Waterbury Filing No. 1
Traffic Impact Analysis
SF237
(LSC #204222)
December 24, 2024

LSC Responses to TIS Redline Comments

### Recommended Turn Bay Geometry Saybrook Road at Stapleton Drive

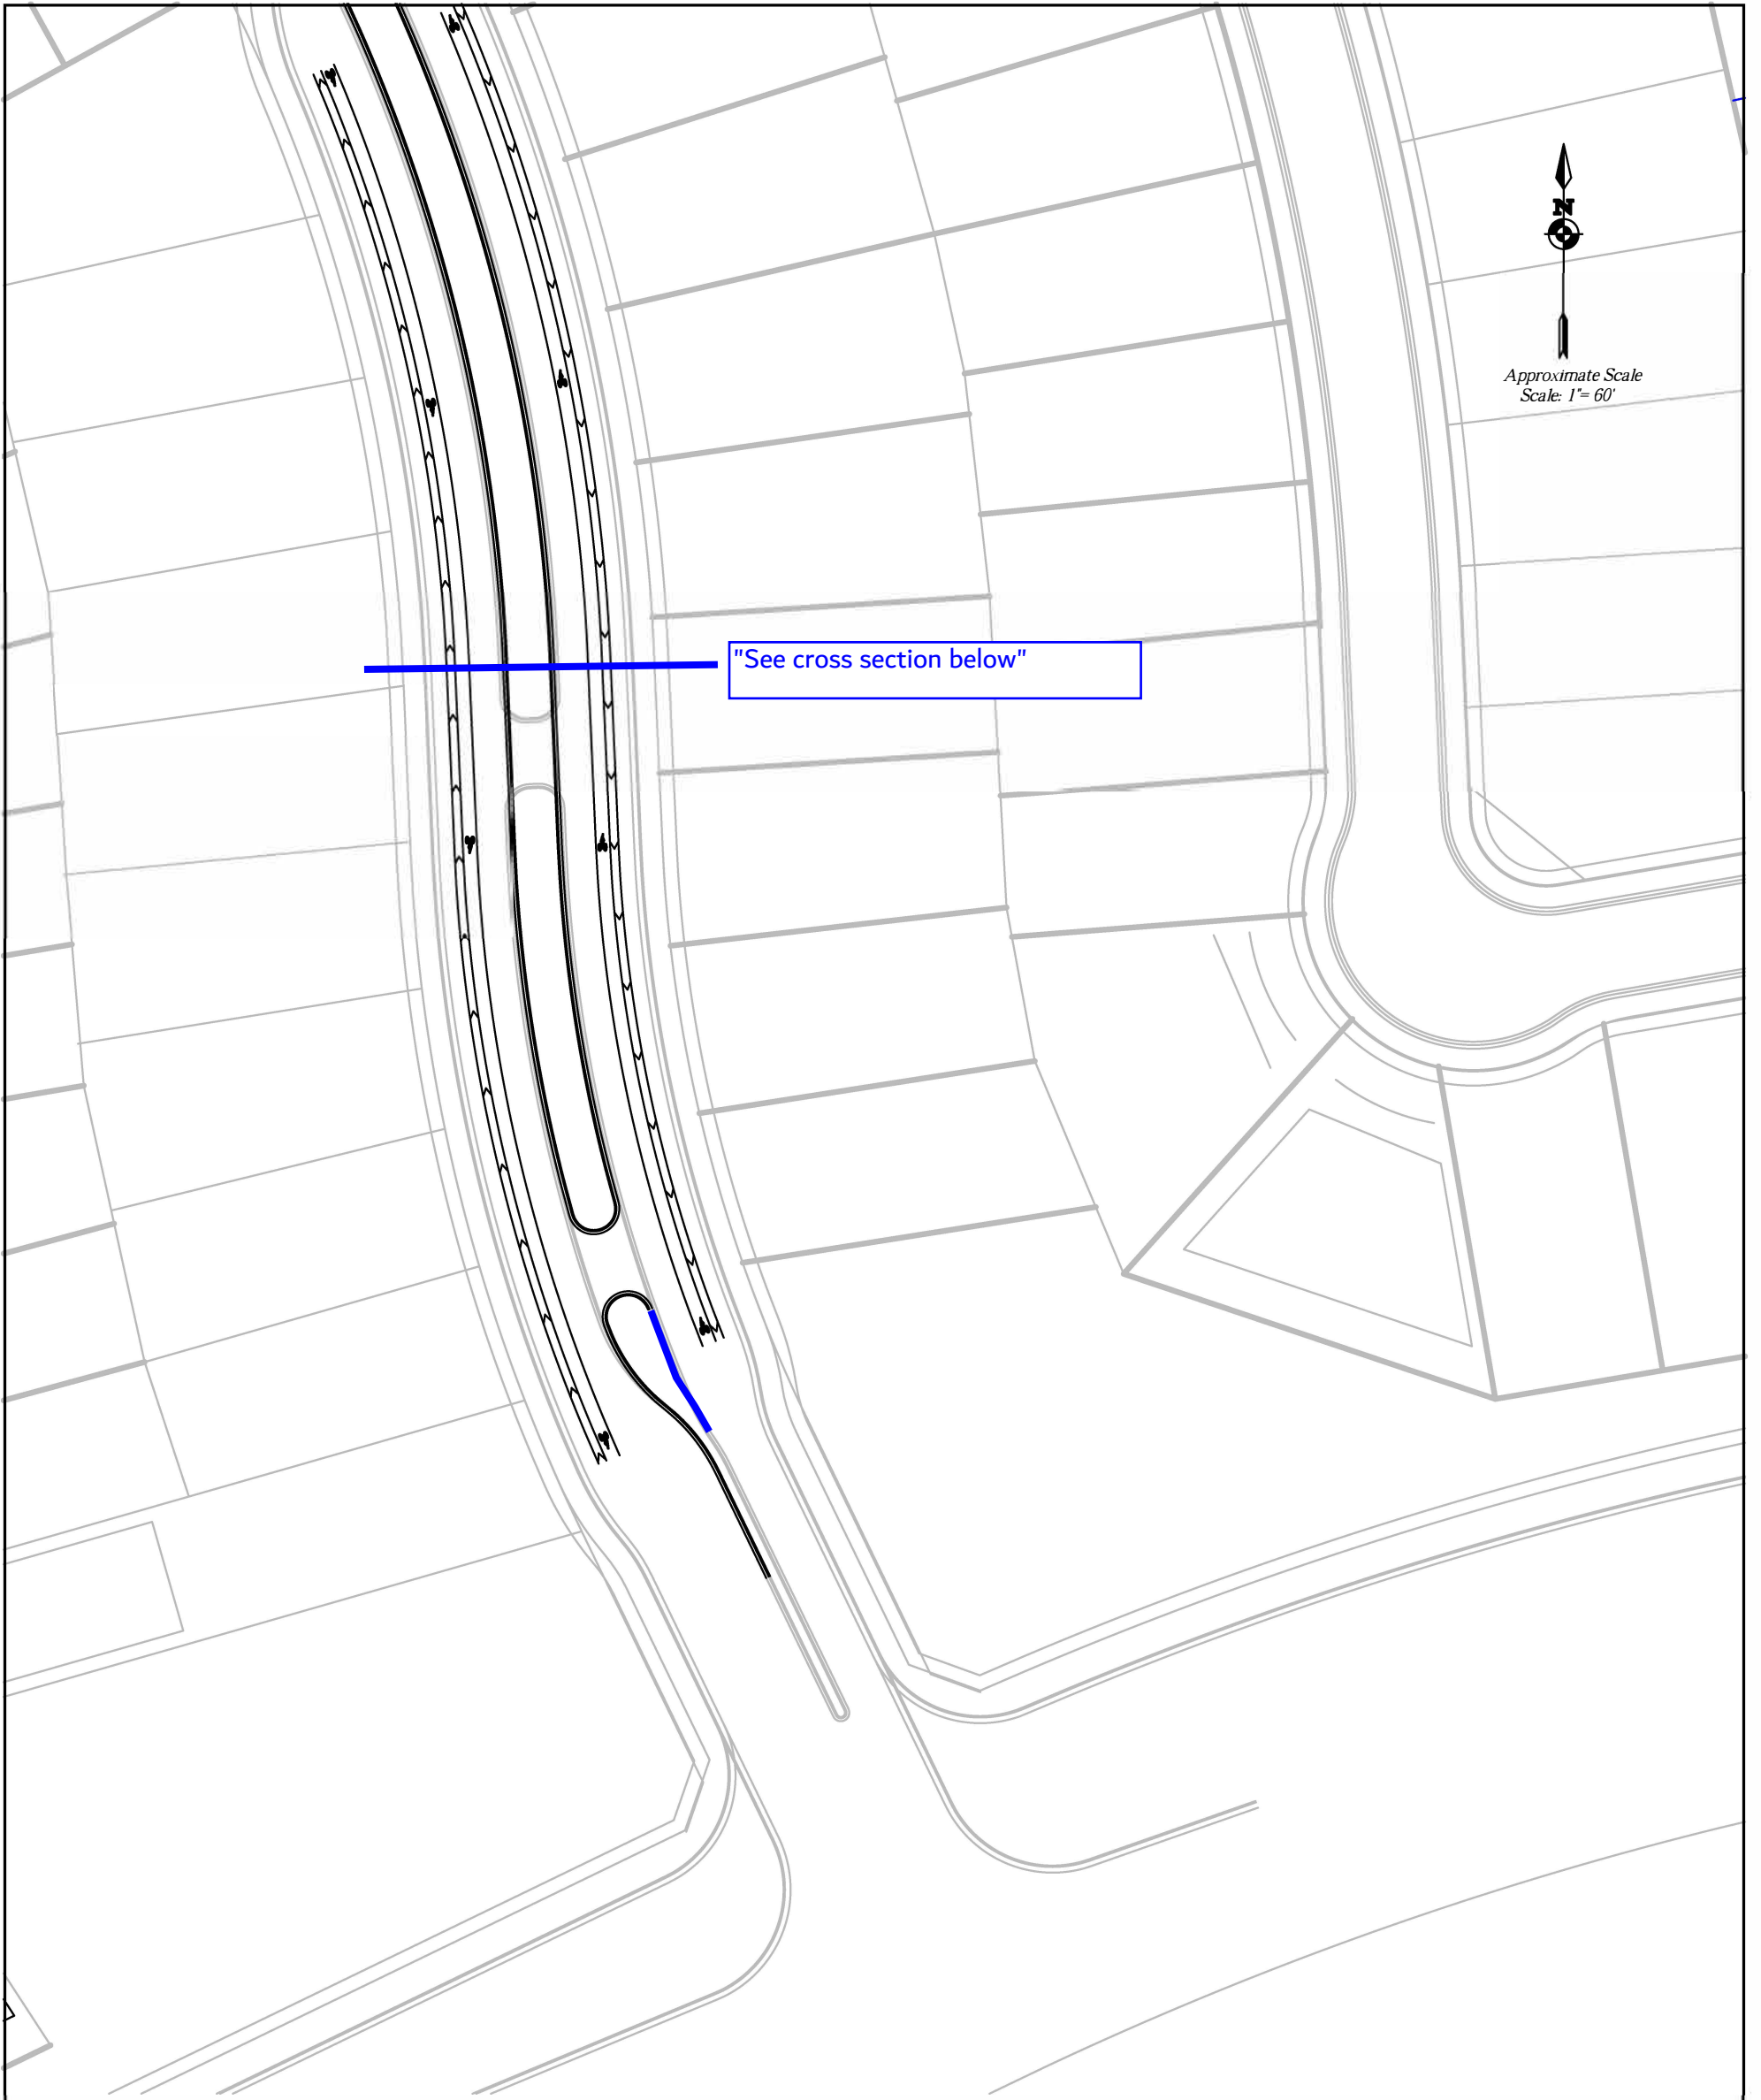
Number: 1 Author: Jeff Rice - EPC Engineering Review Subject: Text Box Date: 1/24/2025 13:30:13

[Remove this](#)

Author: kdfer Subject: Sticky Note Date: 2/6/2025 10:22:24
LSC Response: Removed as requested
